Gatwick Airport Northern Runway Project

Statement of Common Ground Between Gatwick Airport Limited and National Highways

DATE: MARCH 2024

Application Document Ref: 10.1.14

Title
Surface Access Highways Plans
Structure Section Drawings
APFP Regulation 5(2)(o)
Sheet 4
Airport Way Bridge over A23 London Road

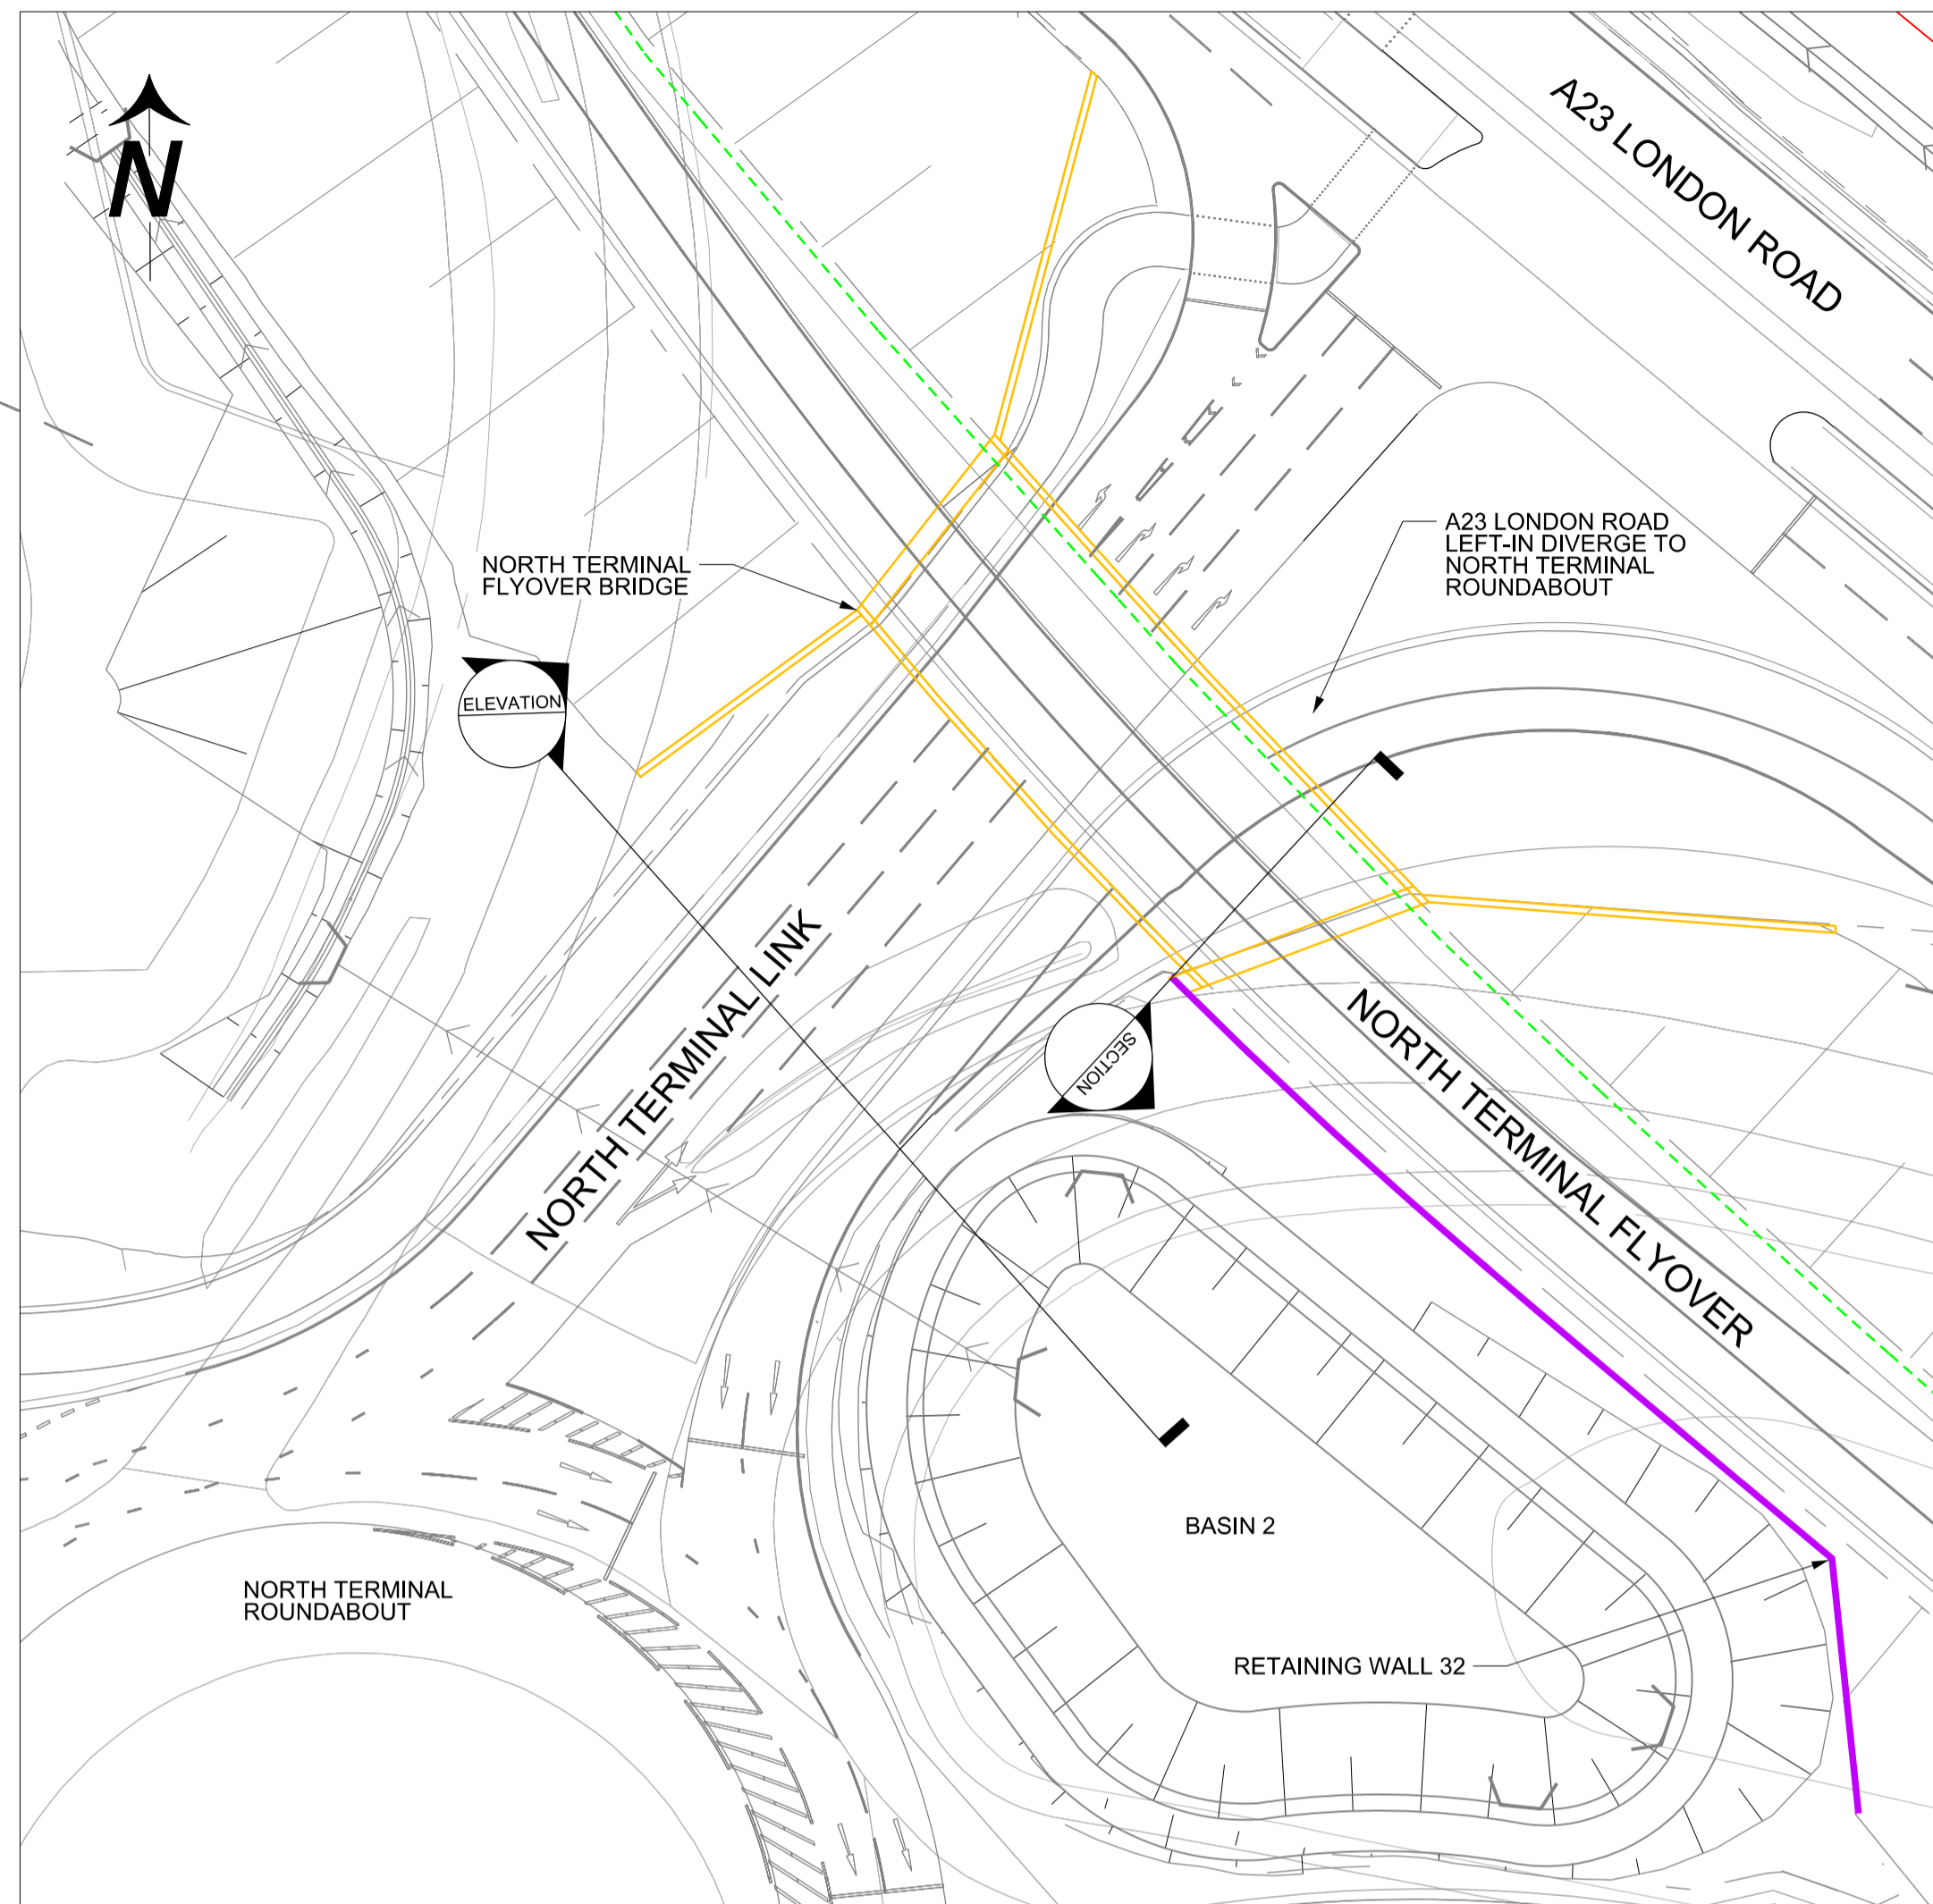
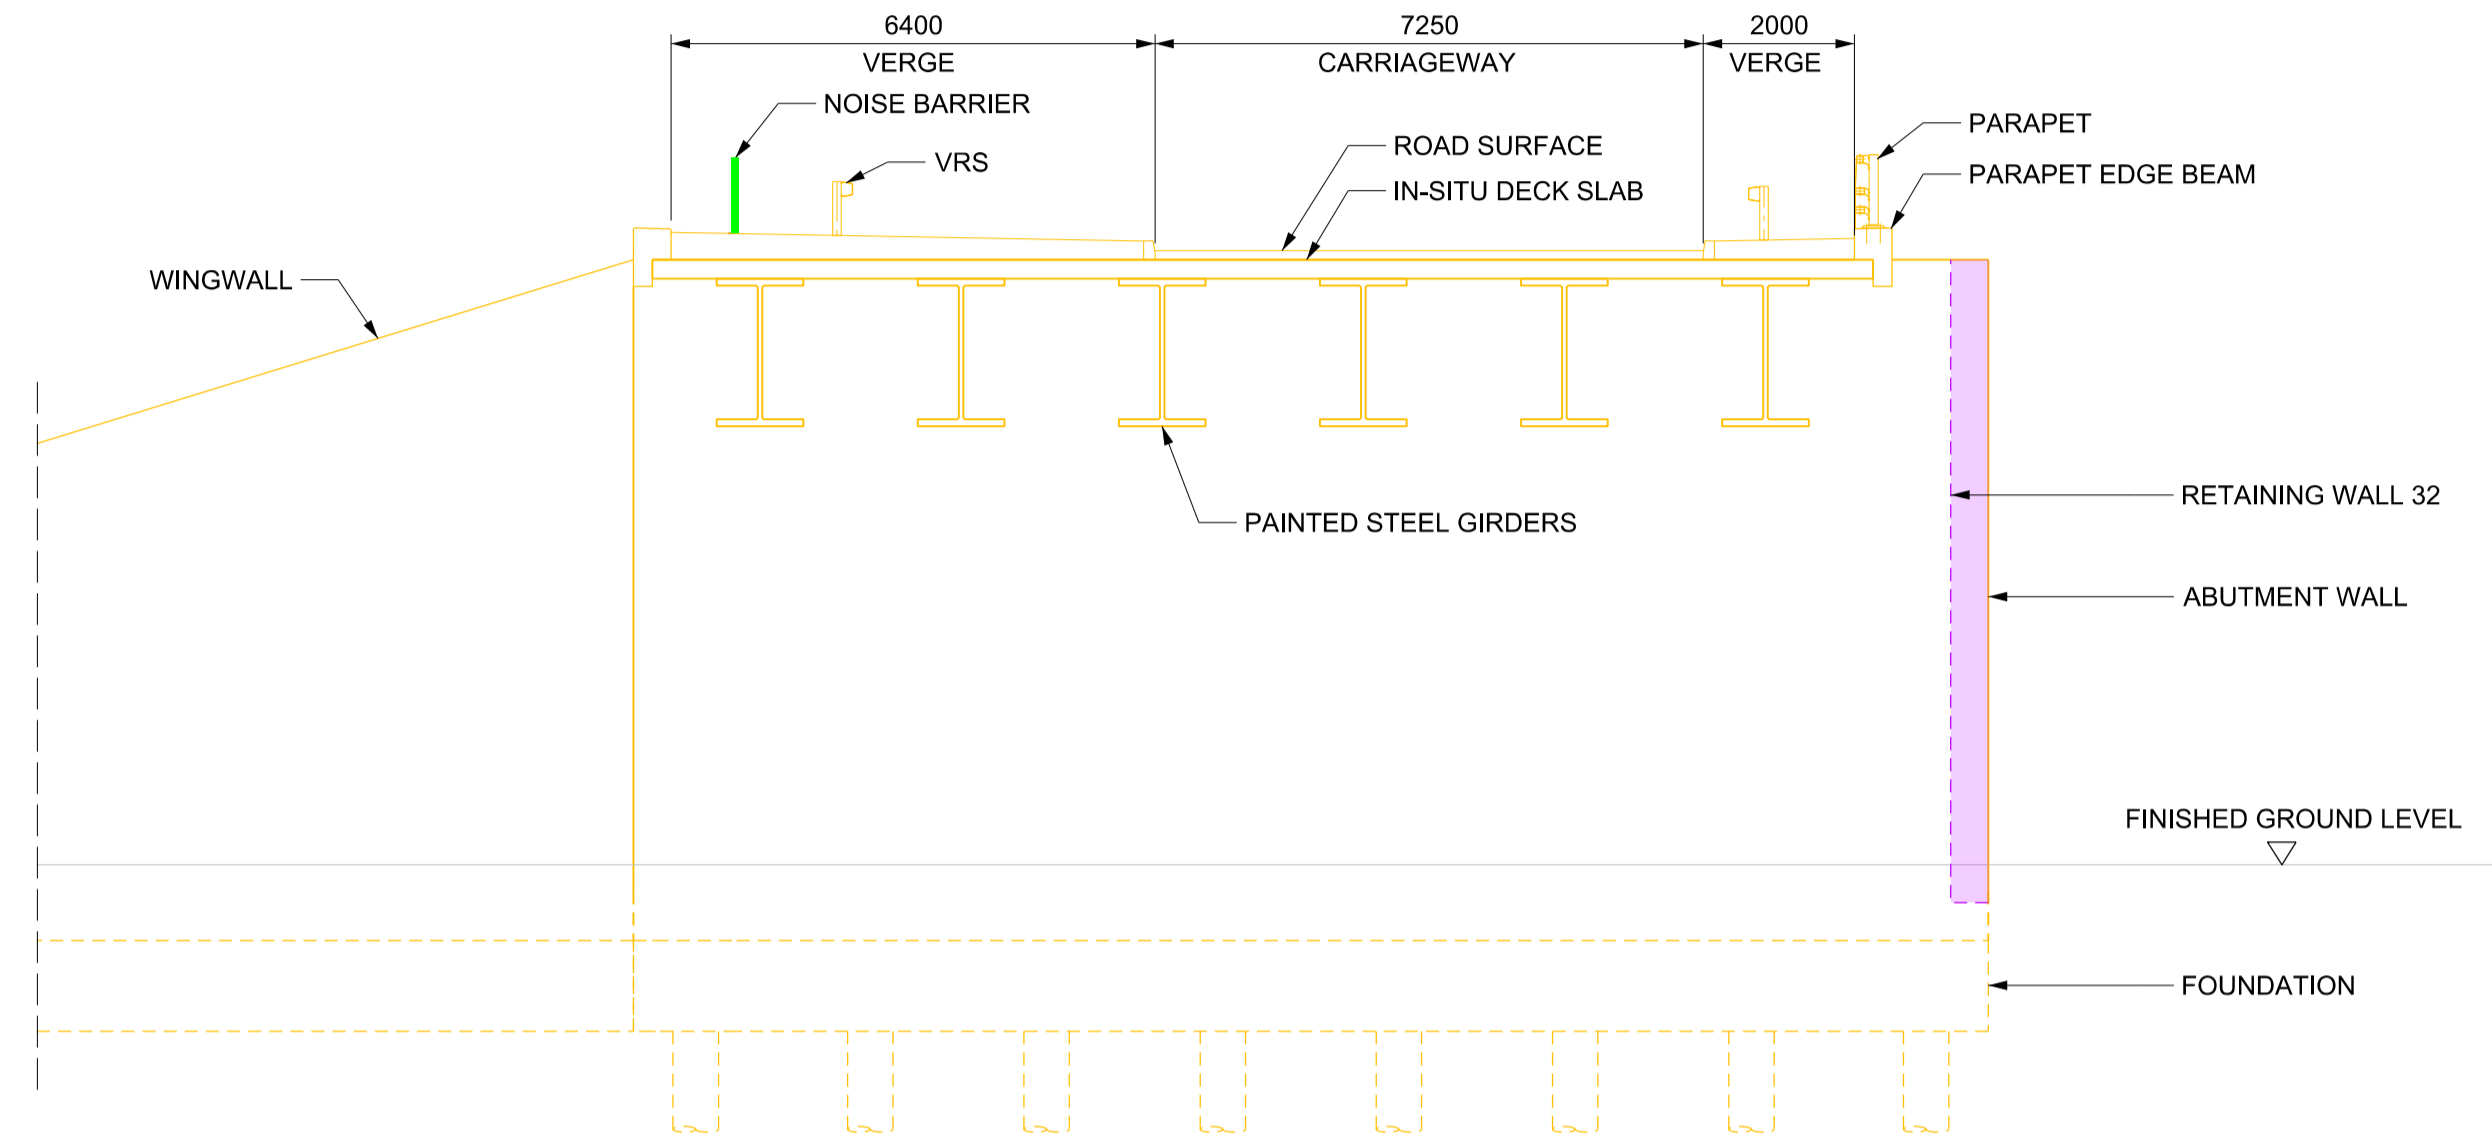
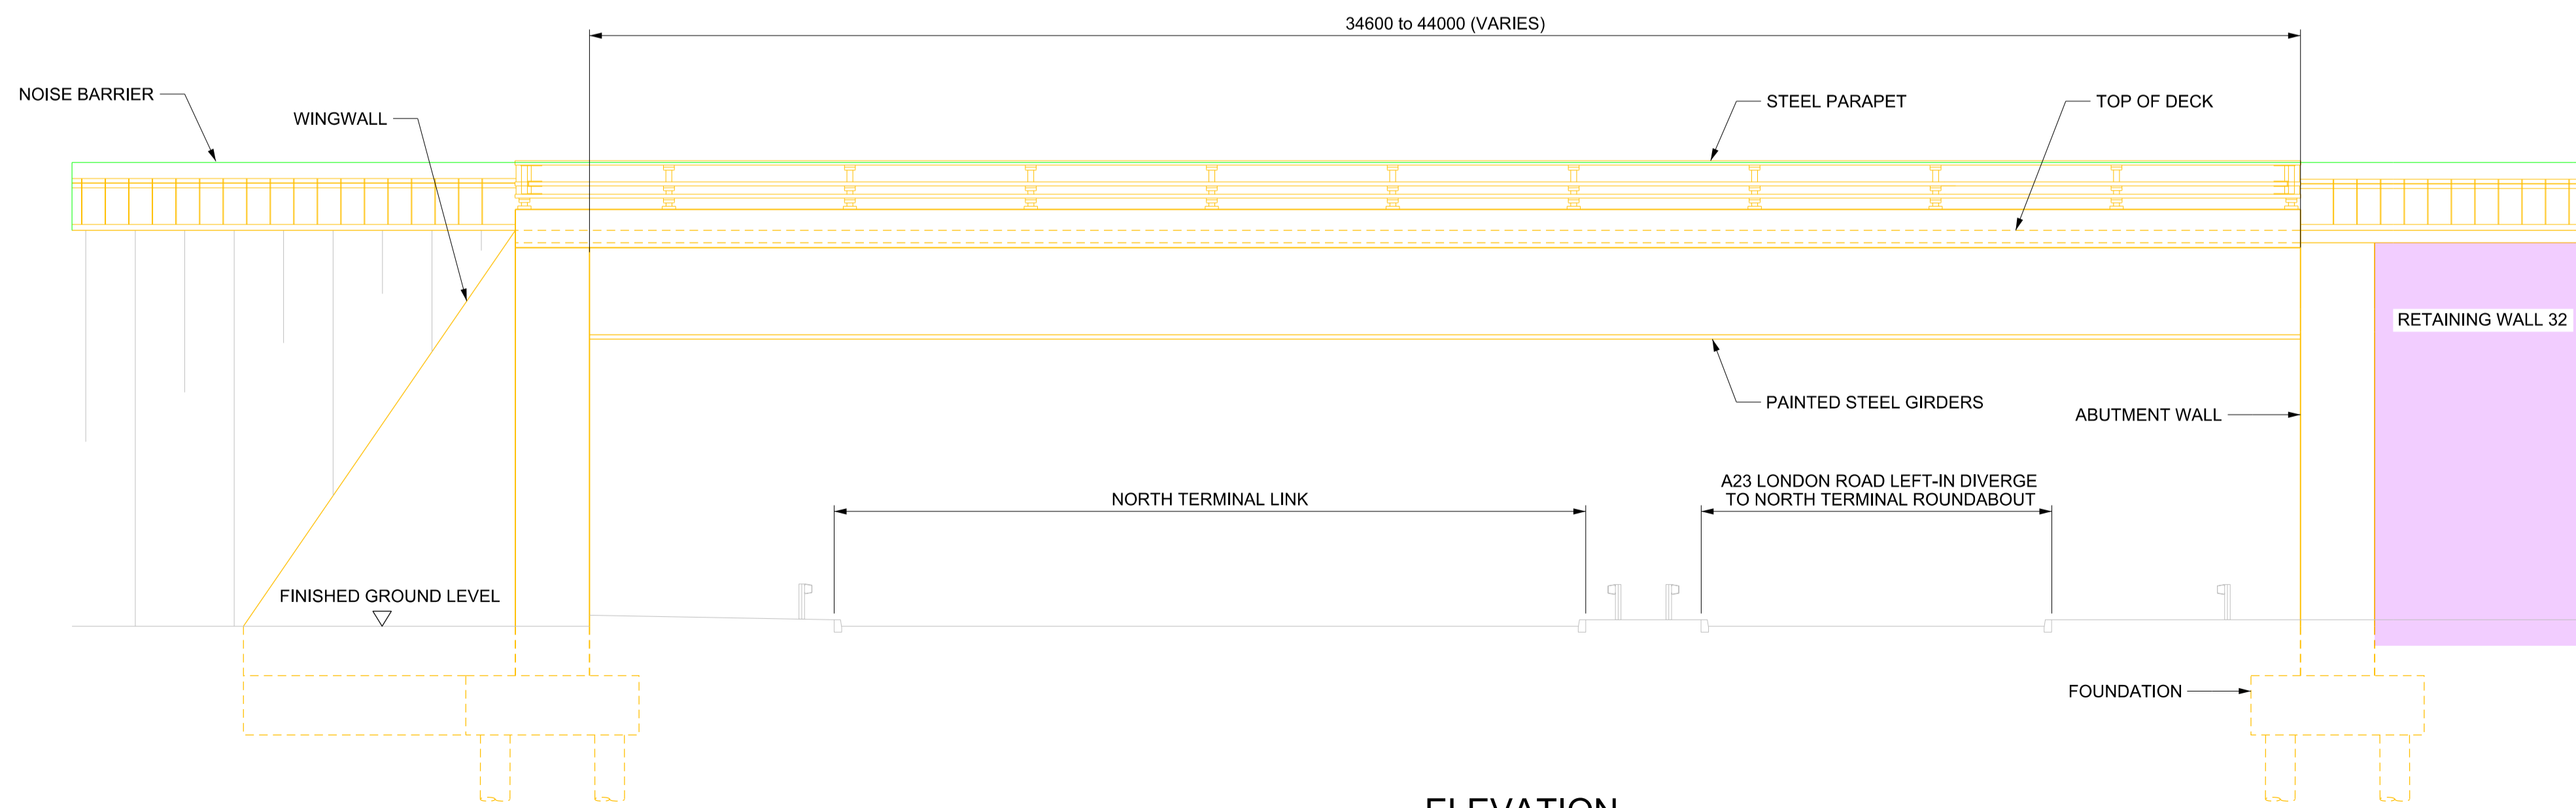
2.5.1.6	<p>Environmental Statement Appendix 5.3.1: Buildability Report Part B Part 1</p> <p>Section 7.3</p>	<p>Relevant Representation (Oct 23) For the Airport Way Bridge over A23 in the Westbound direction, the Applicant's submission does not provide details relating to the proposed vertical profile, cross section and crossfalls.</p> <p>National Highways therefore does not have sufficient information to demonstrate that these elements meet required standards.</p> <p>National Highways requests these details to ensure that the proposed works will meet the required standards and can be deemed to not have a negative impact on the existing structure and the cross section of the structural deck.</p> <p>Updated position (Deadline 1): National Highways requests a dimensioned cross-section for that part of the proposal, to ensure that it aligns with CD 127.</p>	<p>The proposed vertical profile at this location is illustrated in Section 7 on Sheet 3 of the Surface Access Highways Plans – Engineering Section Drawings with chainage information provided on Sheet 1 of this drawing set. Structure sections for this bridge are provided in Sheet 4 of the Surface Access Highways Plans – Structure Section Drawing. The proposed Airport Way westbound carriageway is to be at a similar level to the existing Airport Way carriageway over the bridge deck, noting the removal of the eastbound carriageway provision and the realignment of the westbound carriageway. No structural changes are proposed to the existing reinforced concrete slab bridge deck at this stage.</p> <p>The design proposals at this location have formed part of ongoing technical engagement with the NH SES Structures Team. The detailed design of the bridge including the final vertical profile, cross section and crossfall provision will be subject to approval by NH in accordance with the process set out in the National Highways Protective Provisions included in Schedule 9 Part 3 of the draft DCO following relevant guidance and standards.</p>	<p>Surface Access Highways Plans – Structure Section Drawings [APP-021]</p> <p>Schedule 9 Part 3 of the Draft DCO (Doc Ref. 2.1)</p>	Under discussion
